From: Arun District Council Greenspace

Application ref: A/76/20/PL

Description: 84 No. dwellings, public open space, play areas, associated infrastructure & landscaping. This application affects a Right of Way.

Location: Land at Dappers Lane Angmering

NORTHERN PUBLIC OPEN SPACE

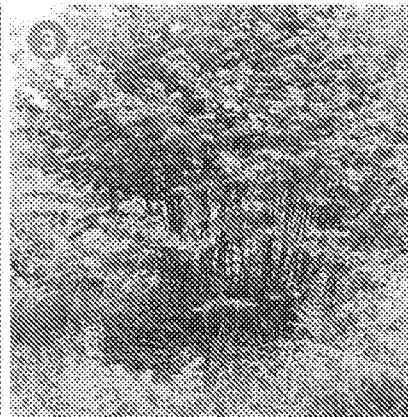
3. LEAP – good to see the use of timber equipment material choice for the play here and that the safety surfacing now bonded rubber mulch. Pathways shown as spray and chip which should allow for year round pedestrian and wheeled access. Hazel coppice is still indicated, which would require specific maintenance requirements and has the potential to become overgrown with time, therefore the value of such of questionable value.
